# SSD 16\_7539: DARLINGTON TERRACES MIXED USE DEVELOPMENT

## THE UNIVERSITY OF SYDNEY, DARLINGTON CAMPUS

### AMENDMENT TO THE PROPOSAL

### RESPONSE TO SUBMISSIONS

4 15 JULY 3PM

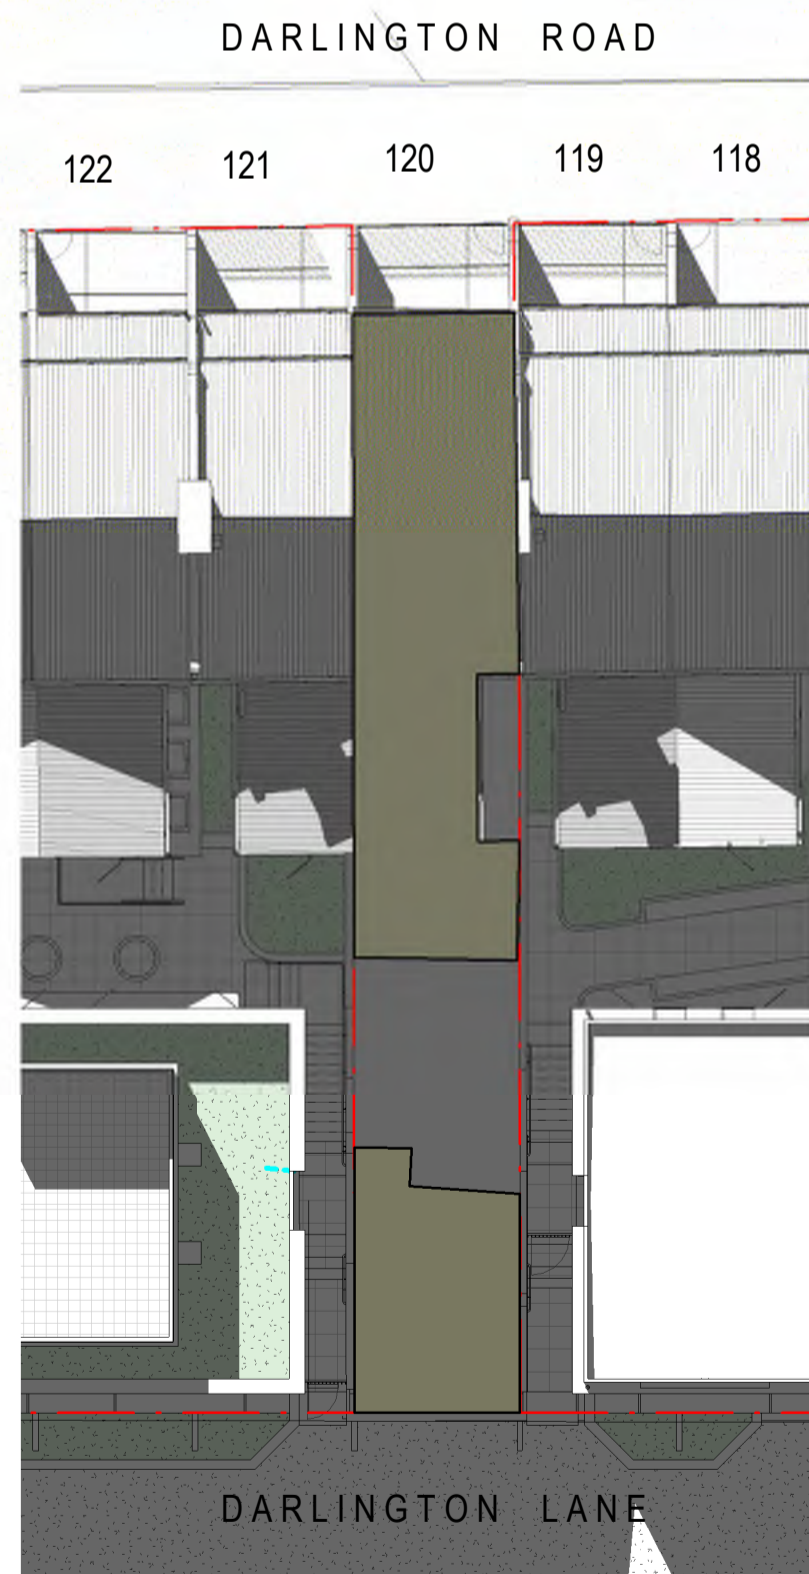
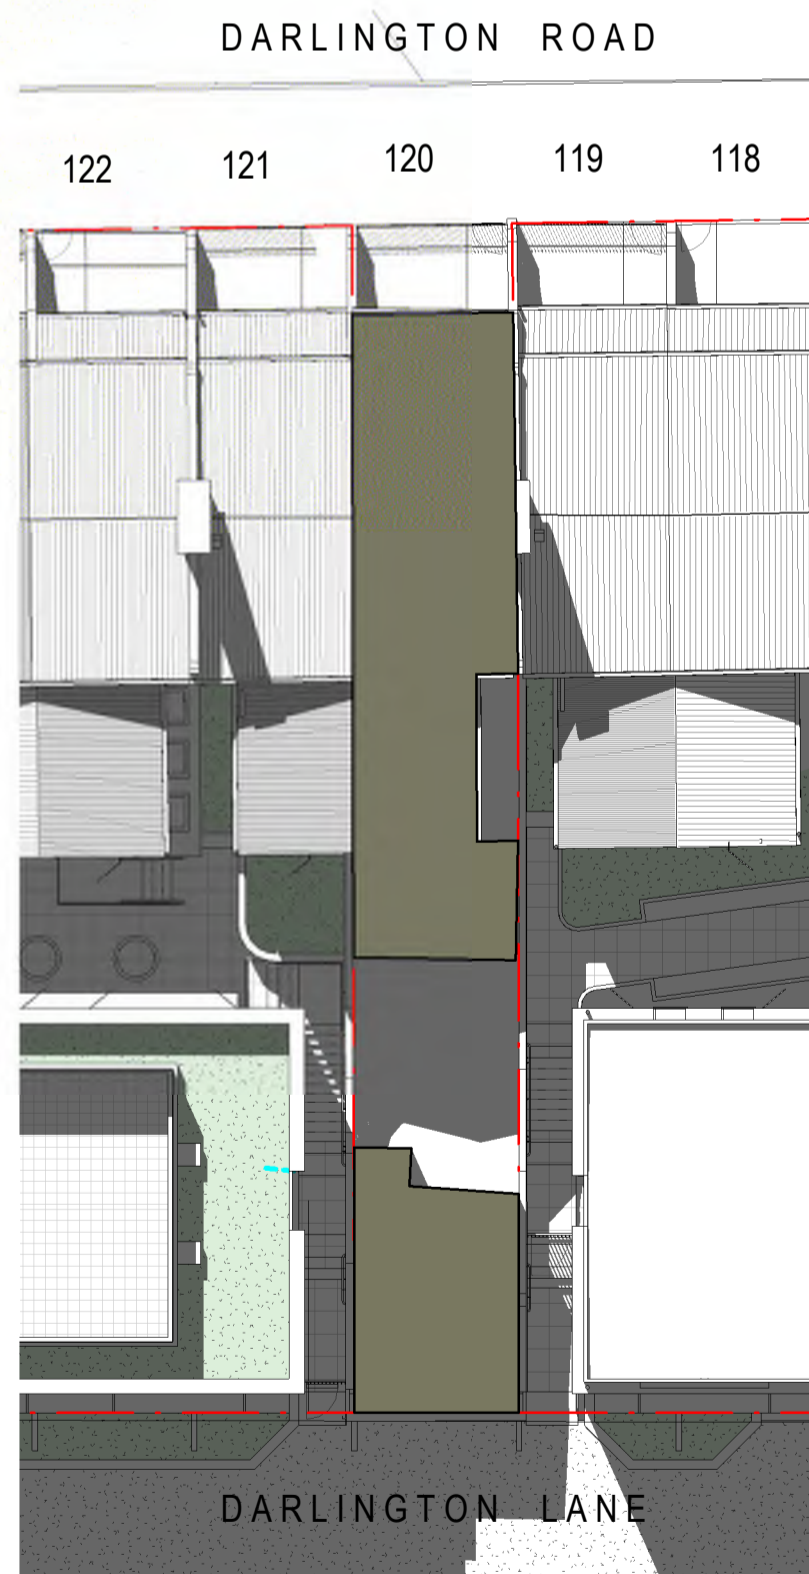
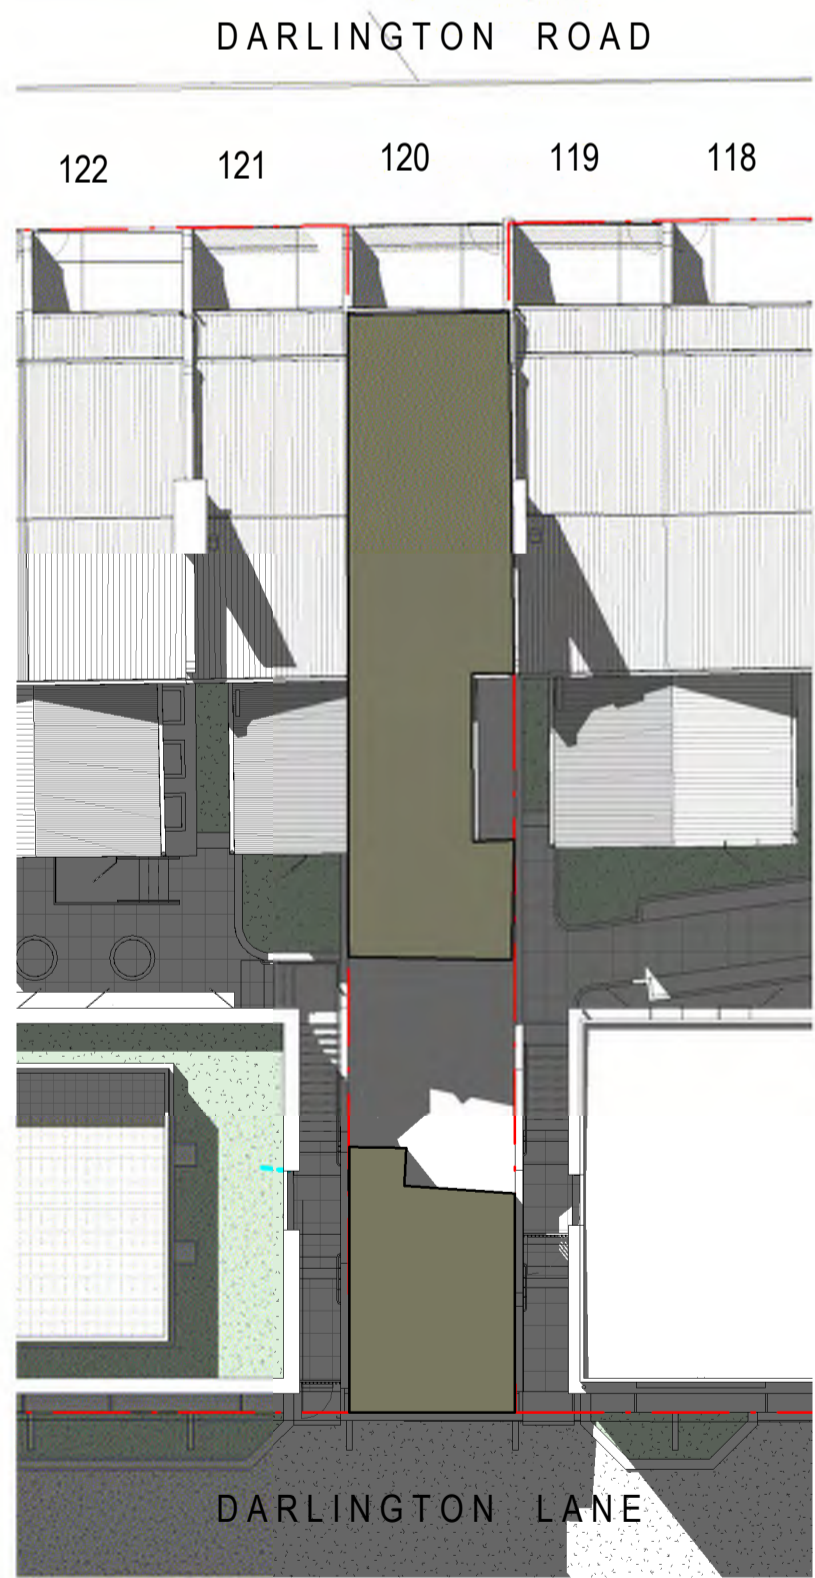
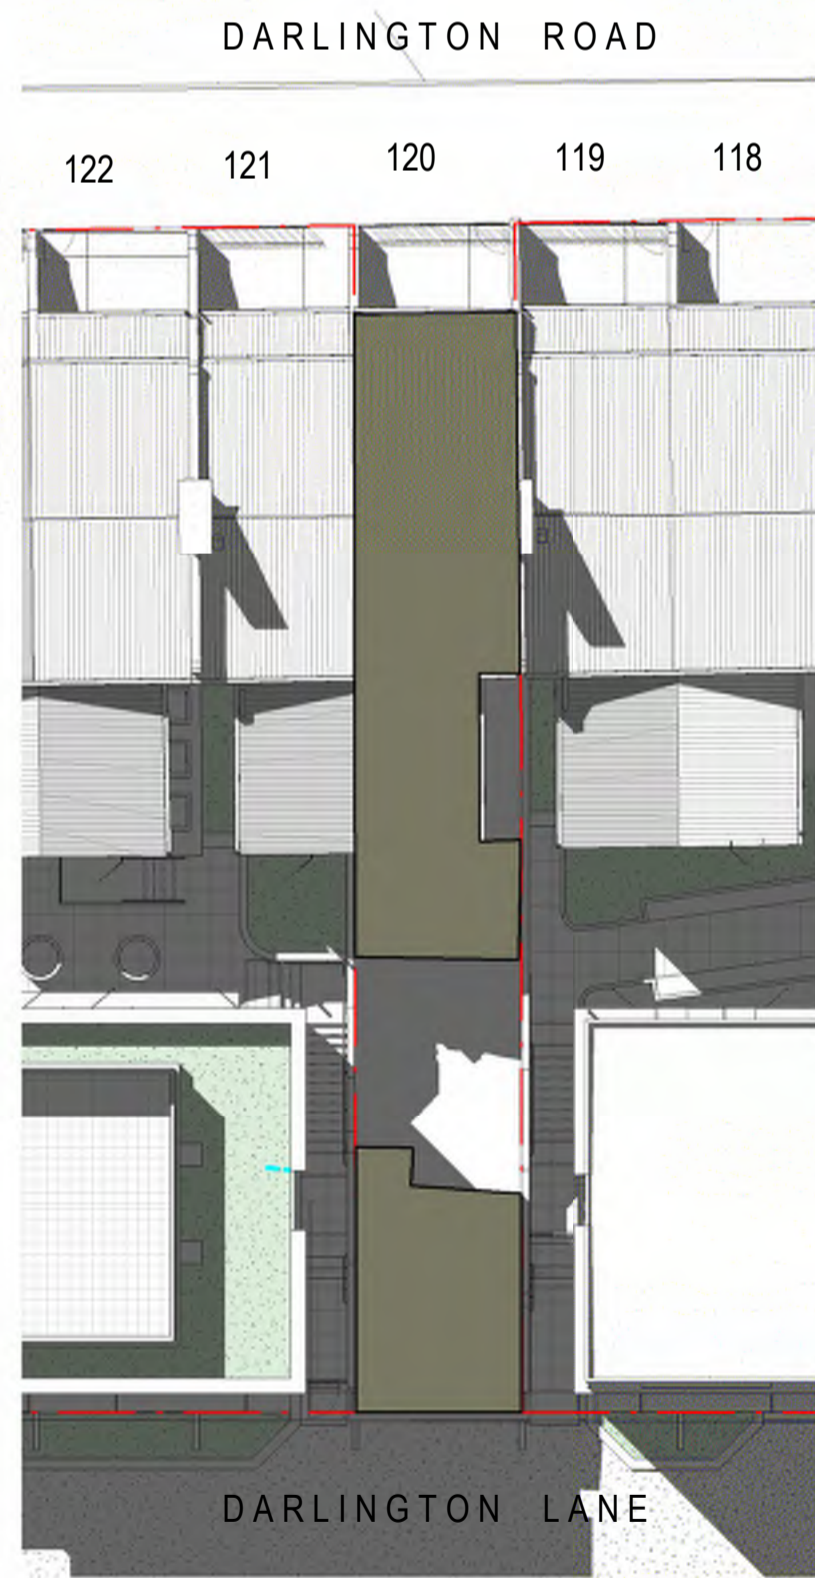
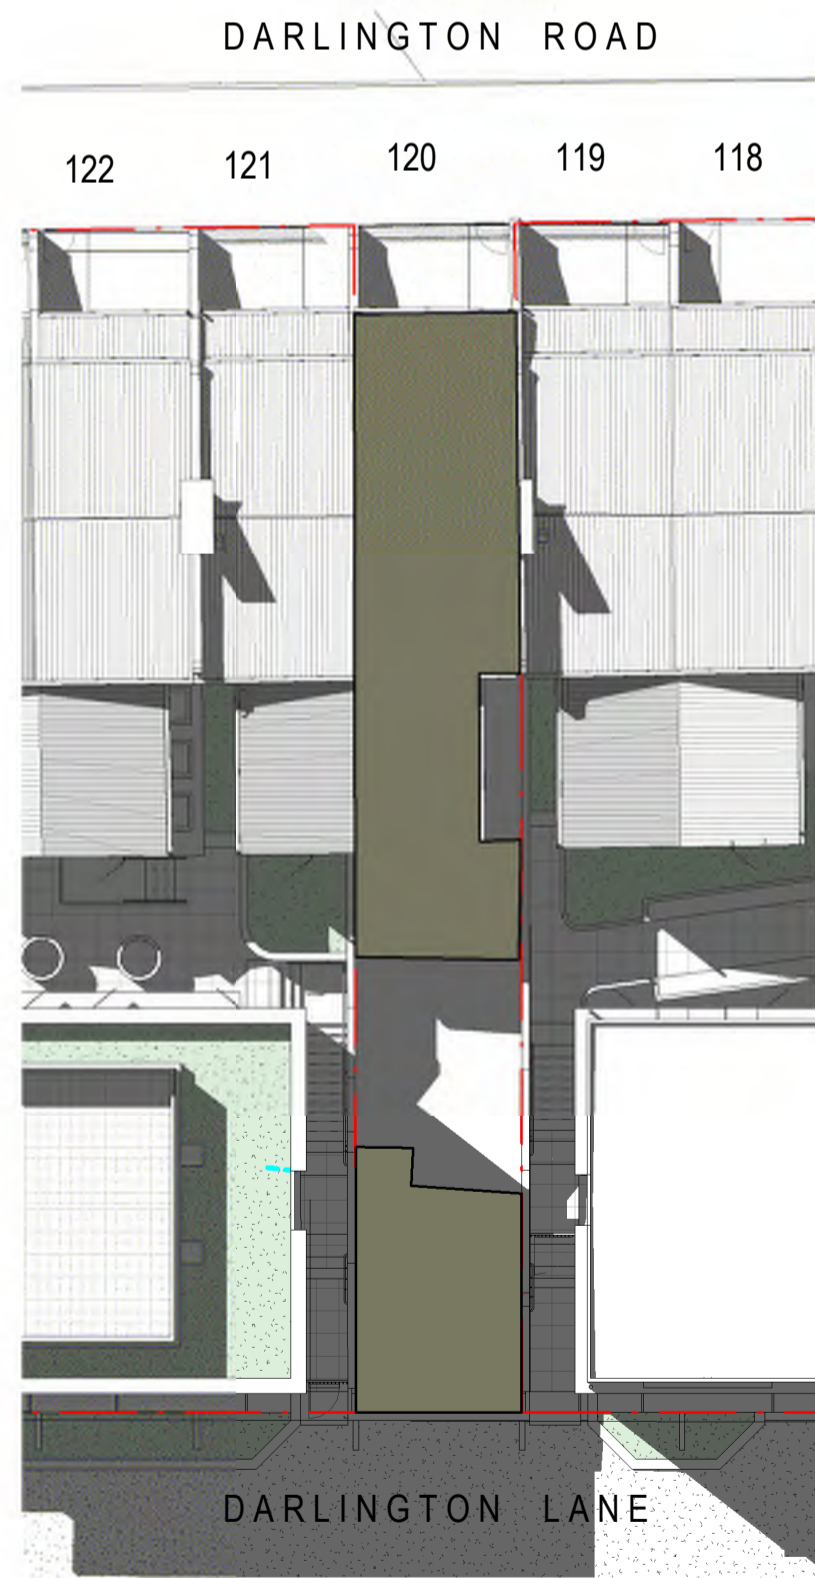
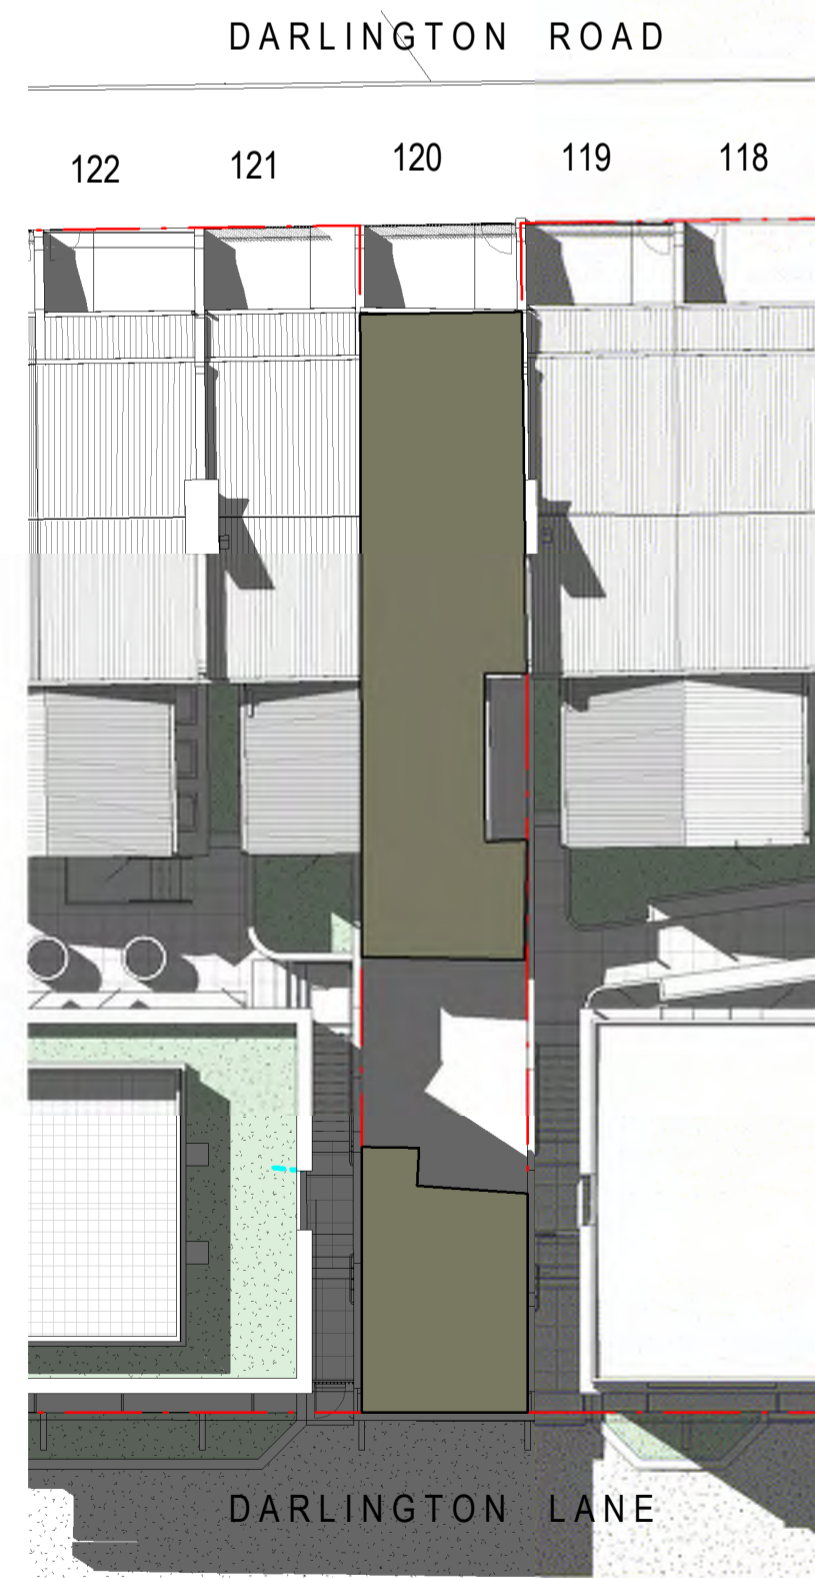
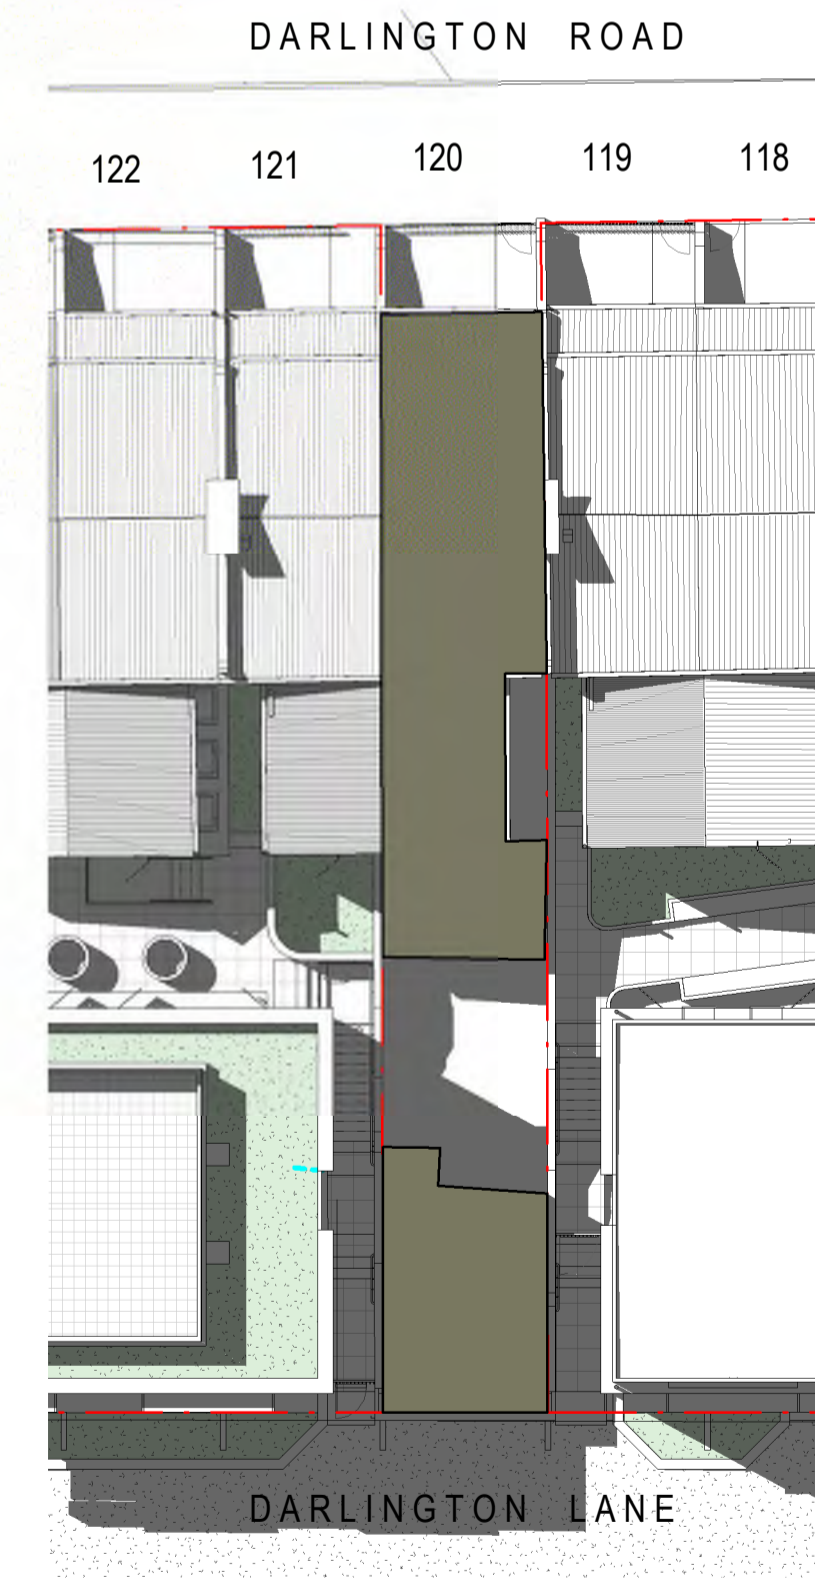
<p><b>Residential Amenity</b></p> <p>3. The overshadowing analysis must illustrate that adequate solar access has been maintained to the adjoining private residential properties and additional overshadowing from the proposal does not result affected properties retaining less than a minimum two hours of solar access to 50 per cent of the private open space areas between 9 am and 3 pm on 21 June. Additional shadow diagrams illustrating overshadowing at hourly intervals (at a minimum) must be provided to clearly demonstrate impacts on open space areas of the private residential properties affected by the proposal.</p>	<p><b>Agreed:</b> The amended Shadow Analysis by project architects AJ+C are addressed in the package of Architectural Plans (<b>Appendix A-3</b>). The two privately owned Terraces located in between the proposed new buildings are No’s 120 and 97 Darlington Road and the Shadow impacts to the rear yards of these Terraces are addressed at <b>Appendix A-4</b>.</p> <p>The AJ+C Shadow Analysis confirms that:</p> <ul style="list-style-type: none"> <li>• No. 120 Darlington Road currently receives less than 2 hours sunlight to 50% of open space, and will not receive any additional shadows to the rear yard of the property because of the proposed development; and</li> <li>• No. 97 Darlington Road currently receives less than 2 hours sunlight to 50% of open space. The design of new Building Block D, immediately to the east of and adjoining 97 Darlington Road, has been modified by including a splayed treatment at its north-western corner, in order to avoid any additional overshadowing and thereby ensure that current levels of solar access to the rear yard of (private) 97 Darlington Street are maintained as existing.</li> </ul>

SSD 16_7539 – DARLINGTON TERRACES MIXED USE DEVELOPMENT	
DPIE KEY ISSUE	UNIVERSITY PROJECT RESPONSE
	<p>The AJ+C shadow analysis at <b>Appendix A</b> also includes an hour-by-hour birds eye view of solar access which demonstrates that compliant levels of solar access will be provided to the north facing elevations of the new Darlington Terraces. Solar access to the street front facades of the original Darlington Terraces fronting Darlington Road will remain unaltered.</p>
<p>4. Further <b>Shadow Impacts</b> upon (private) 120 Darlington Road:</p> <ul style="list-style-type: none"> <li>• DPIE acknowledges no mid-winter shadow impacts or any solar reception.</li> <li>• DPIE request an assessment of solar impacts at other times of the year to ascertain what solar access 120 Darlington will receive for min 8sq.m. for period of 2 hours.</li> <li>• If the above-mentioned solar access cannot be received, then USYD to consider built form amendment.</li> <li>• Seek commentary on built form compliance with CIP for solar access.</li> </ul>	<p><b>Agreed:</b> Additional Solar Access Plans (Dwgs DA3910 - DA3913) have been prepared by AJ+C and are found at <b>Appendix A-3</b> (overall mid-winter analysis) and <b>Appendix A-4</b> (for 120 Darlington Road).</p> <p>An analysis of the overshadowing impact of the SSD proposal to the privately owned property at 120 Darlington Road has been conducted on the 1<sup>st</sup> and 15<sup>th</sup> day of each month, and concludes:</p> <ul style="list-style-type: none"> <li>• From 01 January – 01 May (4 months) No.120 Darlington Road will receive 2 hours and above of sunlight to at least 8m<sup>2</sup> of its rear private open space (southern aspect). The property will <b>also</b> receive at least 2 hours and above sunlight to at least 8m<sup>2</sup> of its front private open space facing Darlington Road (northern aspect).</li> <li>• From 01 May – 01 September (4 months) No.120 Darlington Road will receive 2 hours and above of sunlight to at least 8m<sup>2</sup> of its front private open space facing Darlington Road (northern aspect).</li> <li>• From 01 September – 01 January (4 months) No.120 Darlington Road will receive 2 hours and above of sunlight to at least 8m<sup>2</sup> of its rear private open space (southern aspect). The property will <b>also</b> receive at least 2 hours and above of sunlight to at least 8m<sup>2</sup> of its front private open space facing Darlington Road (northern aspect).</li> </ul> <p>✓ In summary, N°.120 Darlington Road will receive at least 2 hours of sun to at least 8m<sup>2</sup> of private open space all year round and will therefore more than satisfy the objectives of <i>Sydney DCP 2012</i> clause 4.1.3.1 <i>Solar Access</i>.</p> <p>✓ Notwithstanding the solar access compliance described above, the University confirms that the built form of the rear Darlington Terraces additions complies with the maximum building envelopes approved by the CIP – SSD 13_61123 (refer to AJ+C elevations for plans to illustrate building envelope compliance at <b>Appendix A-2</b>).</p>
